Addendum No. 1

RE: Contract # C204060

Johnston County (U-3334B)

SR-1923 (Booker Dairy Road) From SR-1003 (Buffalo Road) To US-301

| PROJECT REFERENCE NO.<br><b>U-3334B</b>                                     | SHEET NO.<br><b>8</b>   |

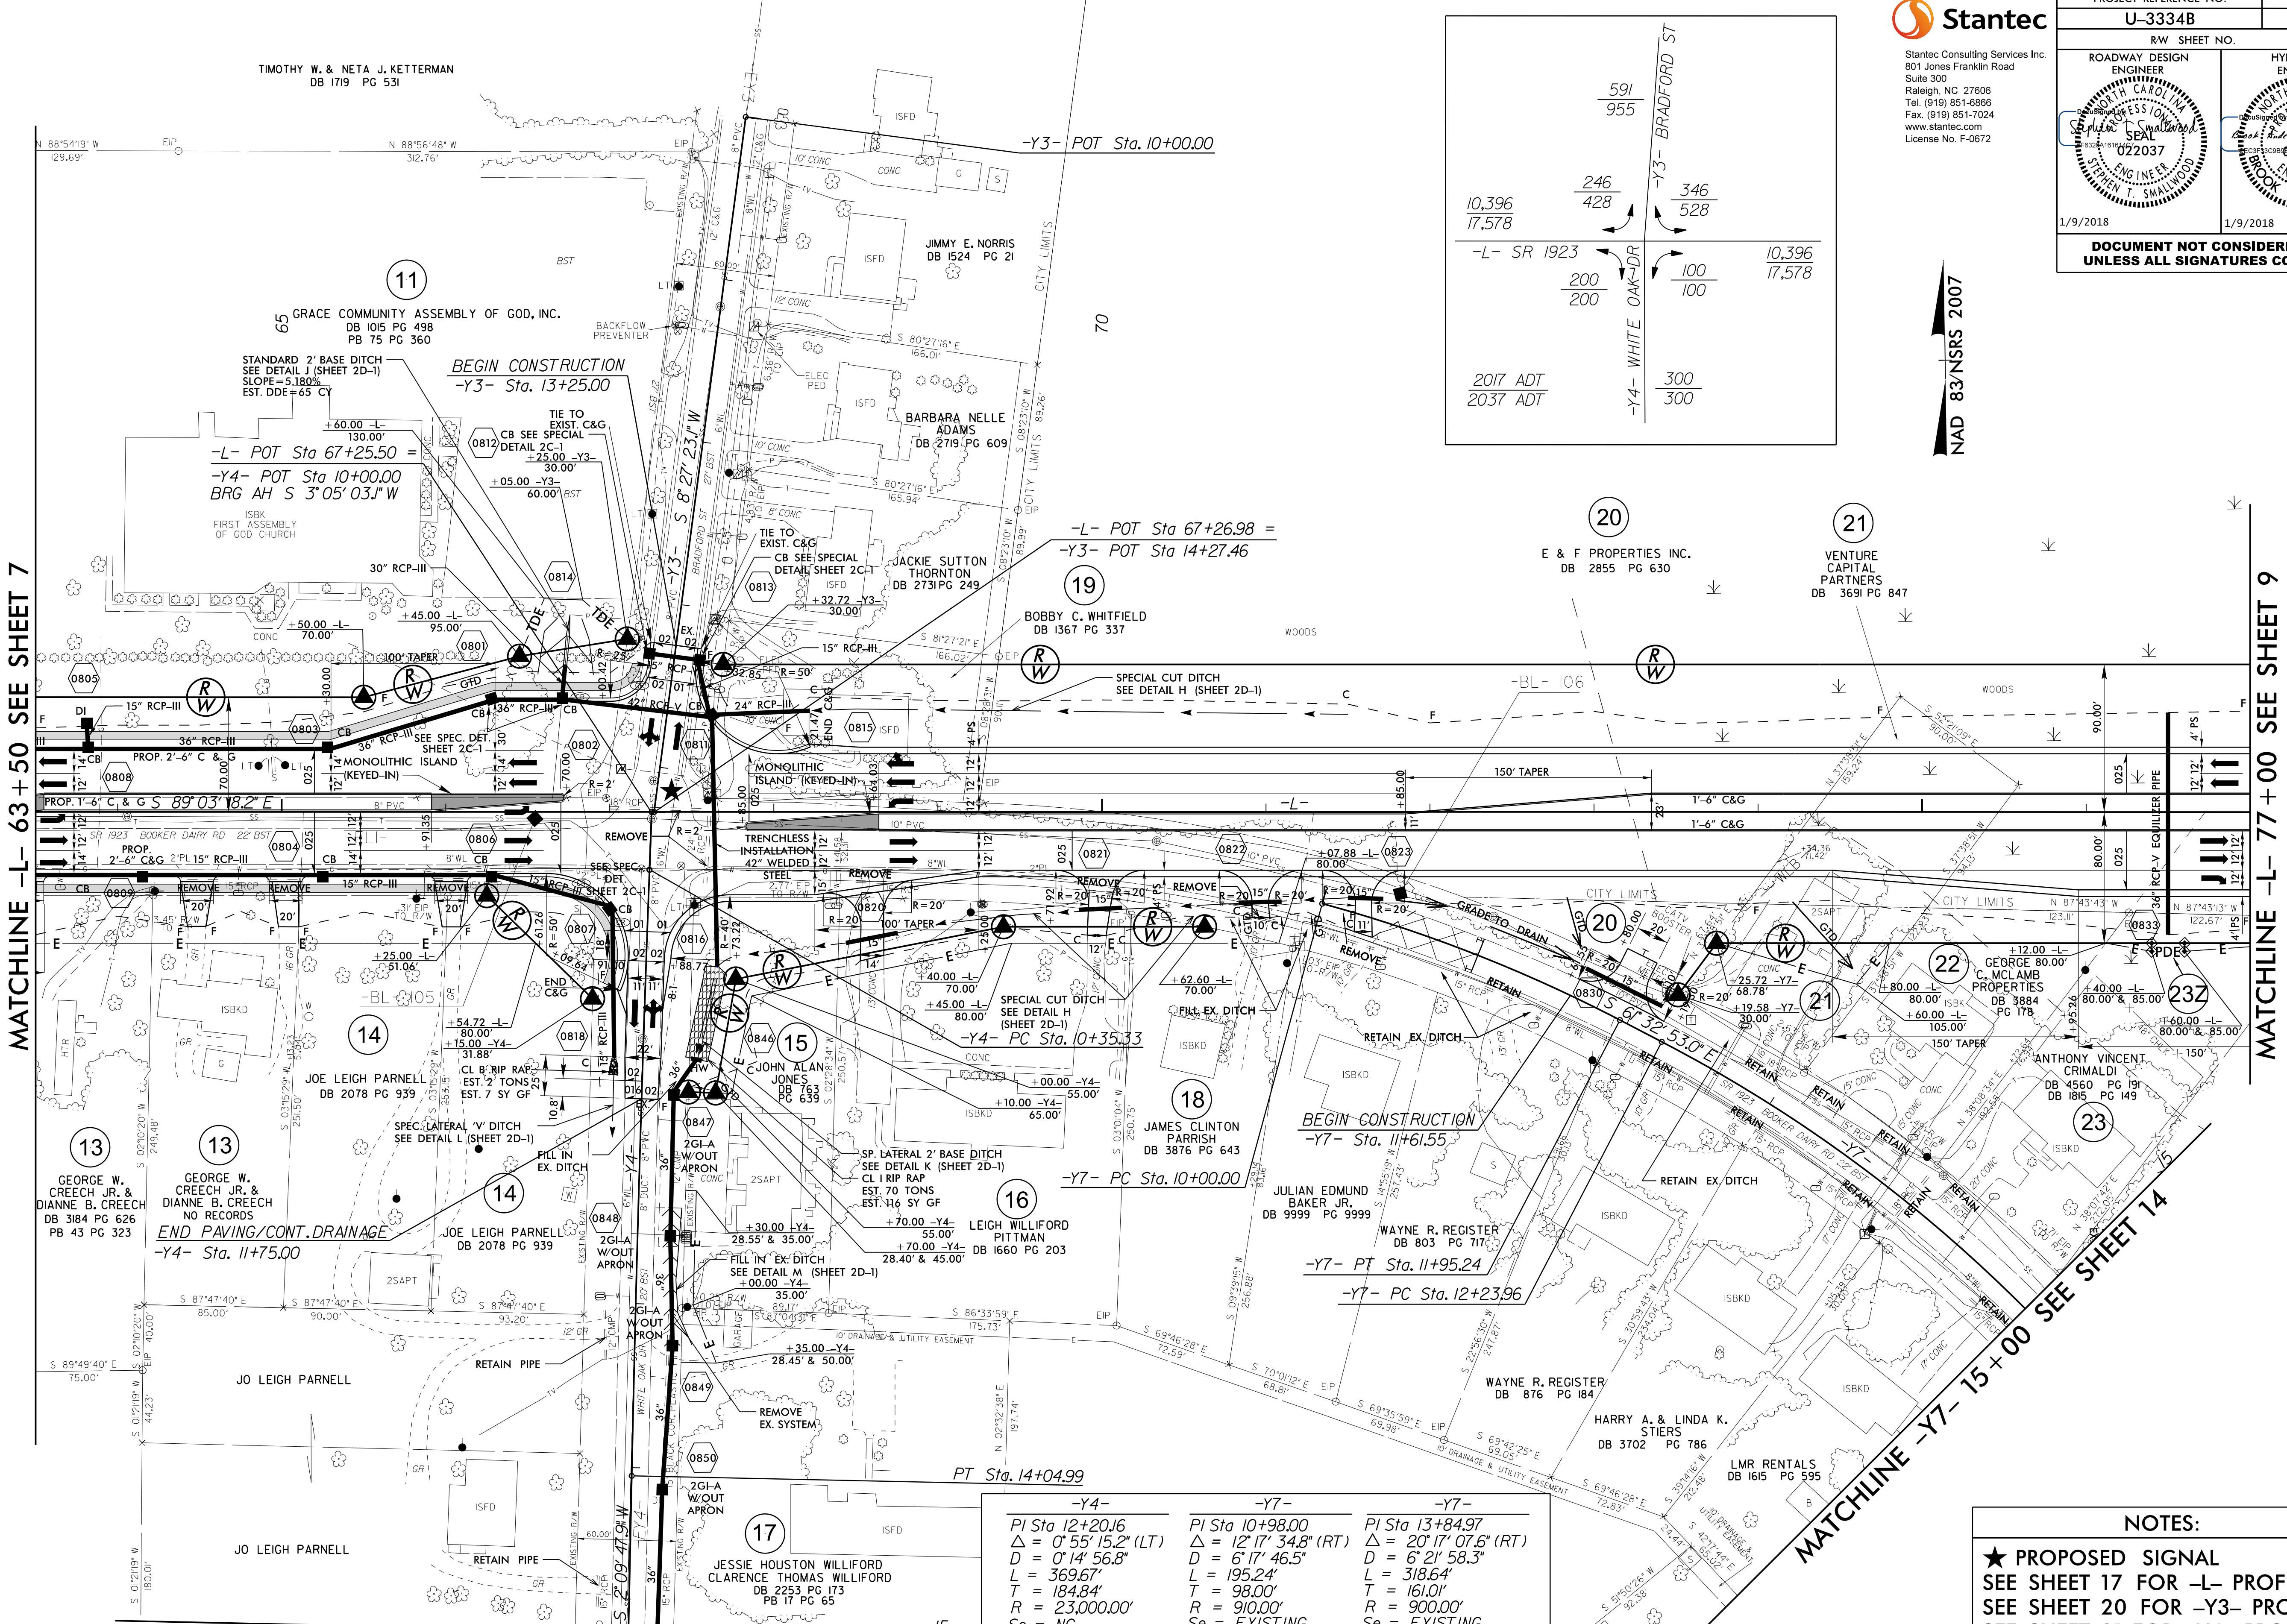
Sheet No.	Revisions
5 and 8	Revised to show trenchless installation of welded steel pipe under the existing road
3D-1 thru 3D-7	Revised to update the Drainage Summaries to reflect the below mentioned quantity changes and pay item additions
TMP-7	Revised to double 36" pipes to one 42" bore under existing roadway
